CITY OF PORTLAND, MAINE
PLANNING BOARD

May 16, 2016

Project Name: Unitil Gas Facility Relocation Project ID: 2016-085
Address: 74 West Commercial Street CBL: 59-A-1-3-4-7-8-11; 59-A-2-5-6-9-10
Applicant: Maine Department of Transportation and Unitil (Northern Utilities, Inc)
Planner: Richard Knowland, Senior Planner

SHEET TITLE	SITE PLAN
PROJECT NAME	WEST COMMERCIAL STREET REGULATOR STATION
PROJECT LOCATION	PORTLAND, ME 04101

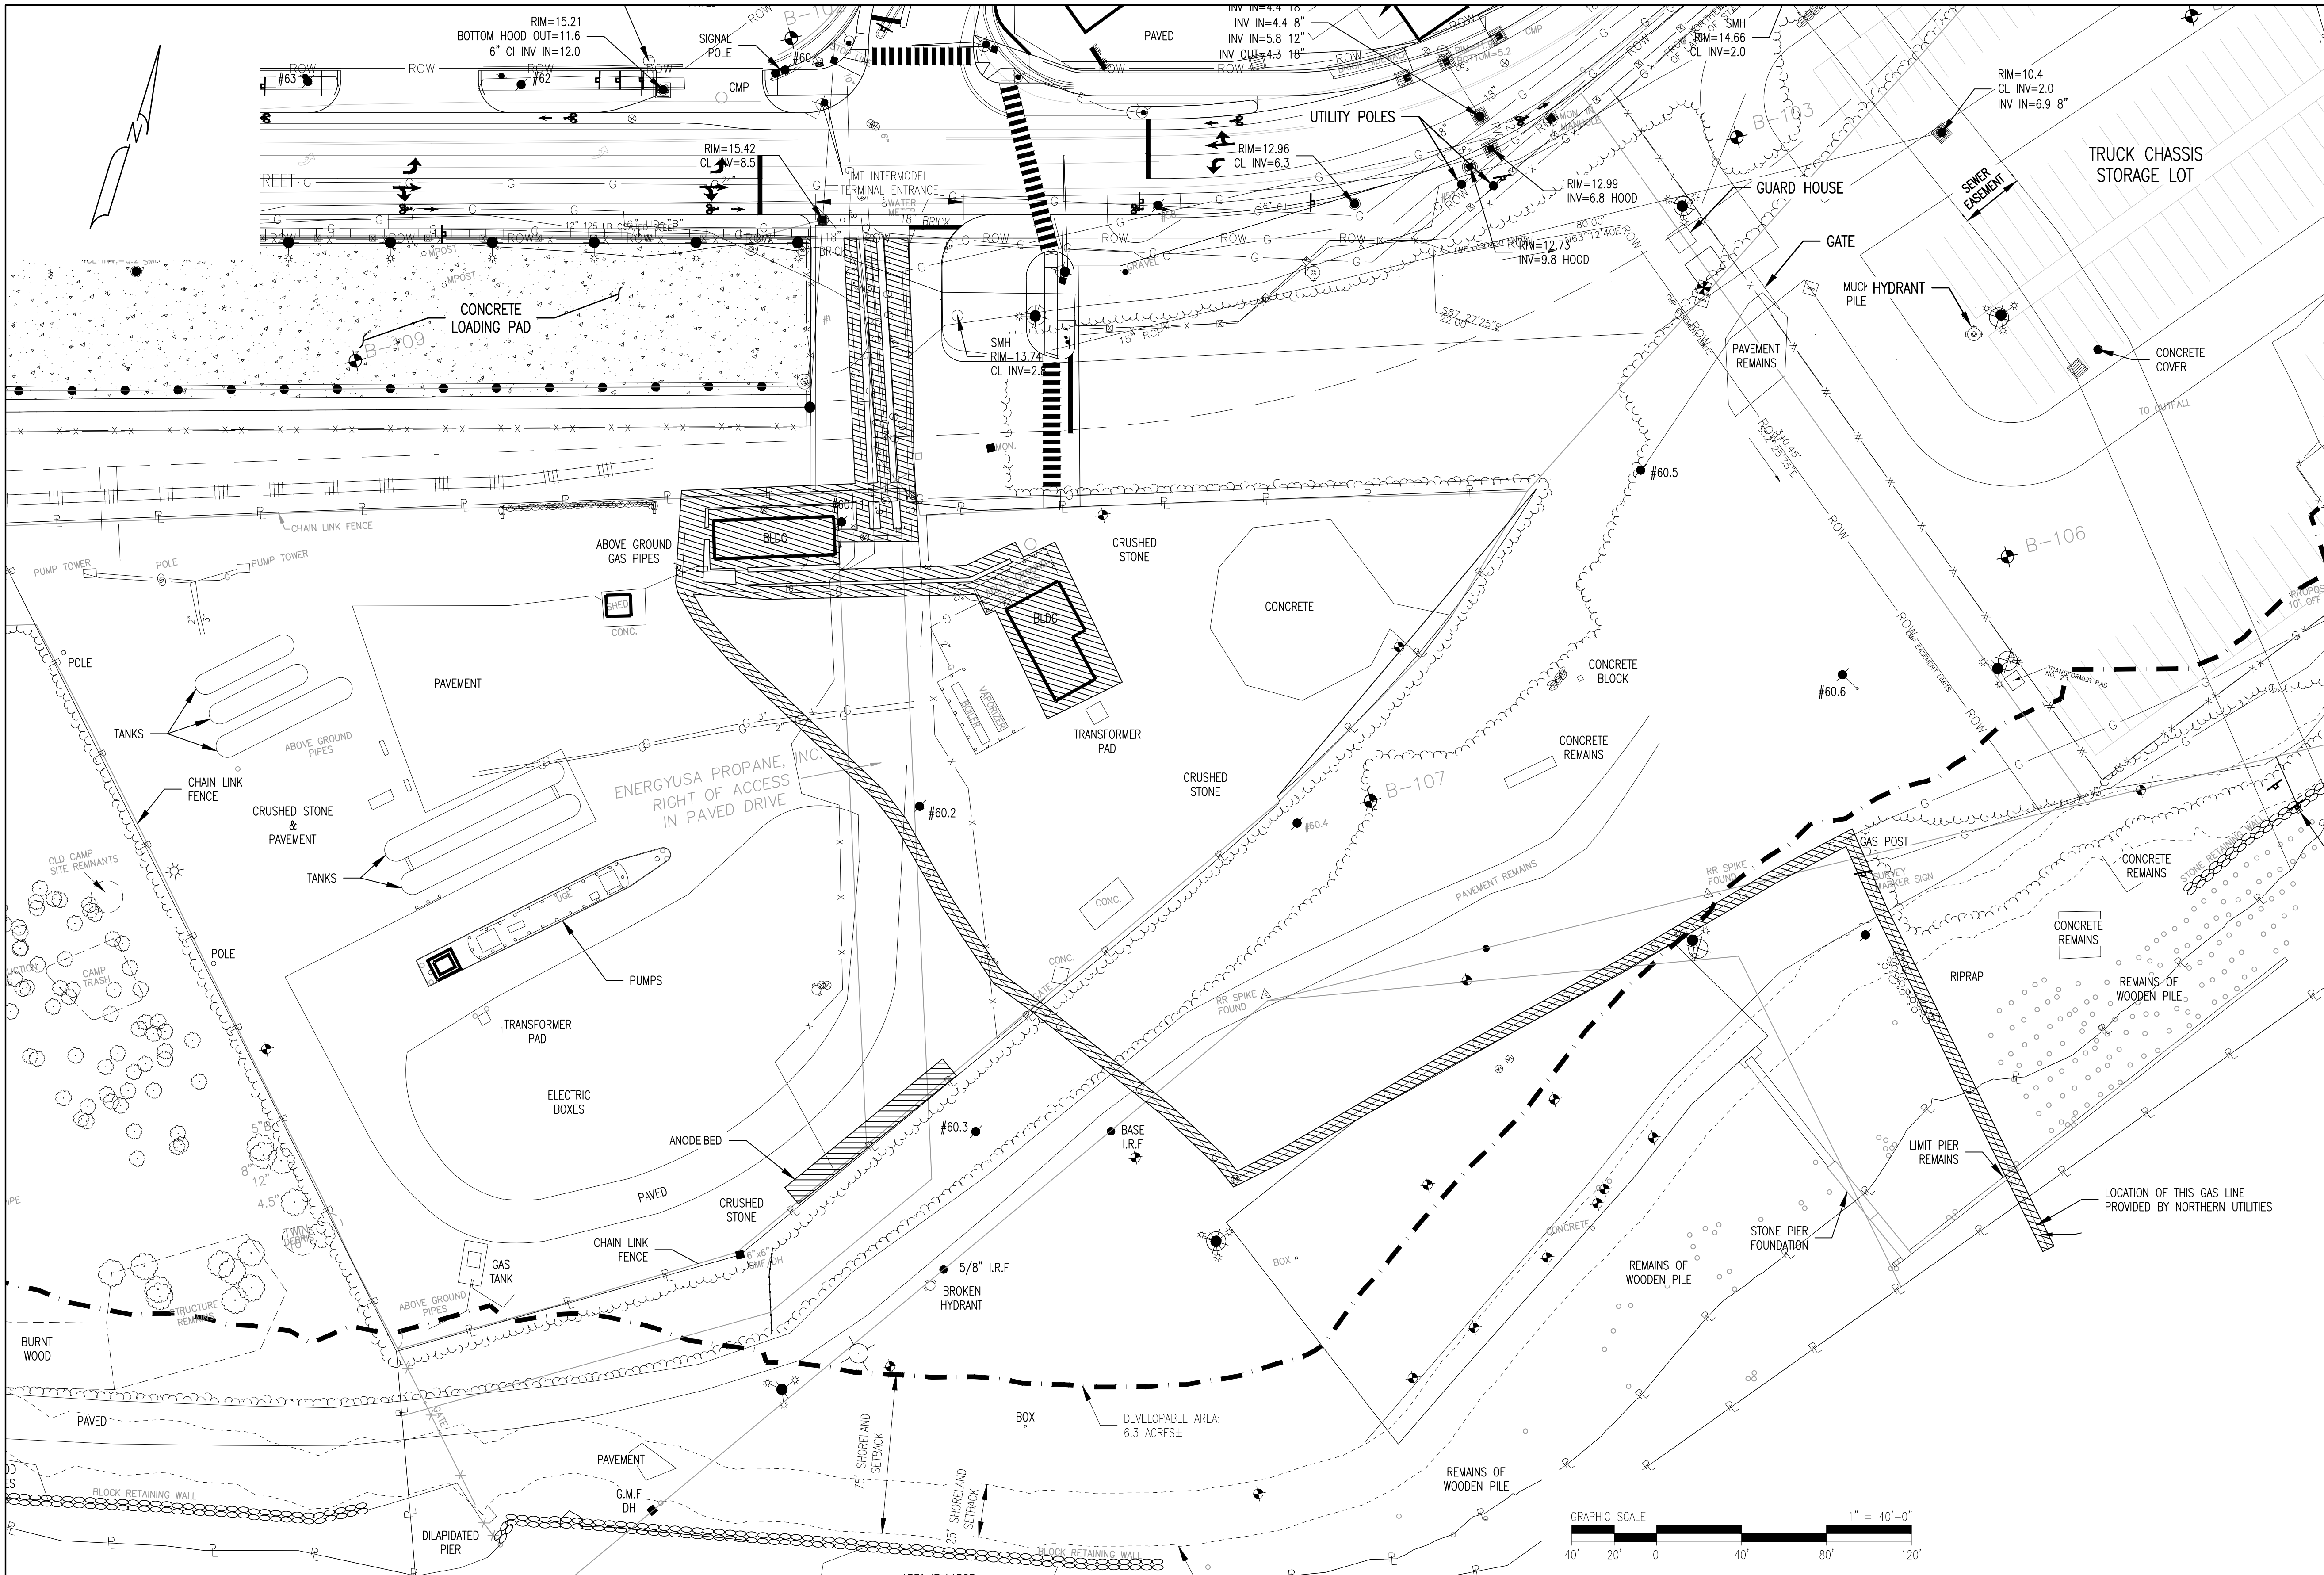
1. That the final site plan of the amended portion of the previously approved site plan shall be re-submitted bearing the stamp of a professional engineer, before the issuance of a building permit.

2. That the site plan shall be revised for City Arborist review and approval reflecting the planting of 5 additional Red Cedar trees (5' to 6' high) along the Commercial Street side of the fence (east of the main driveway) to improve the screening of the site. The final location of the trees shall consider the presence of utilities.
3. That the final site plan shall be updated for Planning Authority review and approval reflecting the location of new exterior lighting.
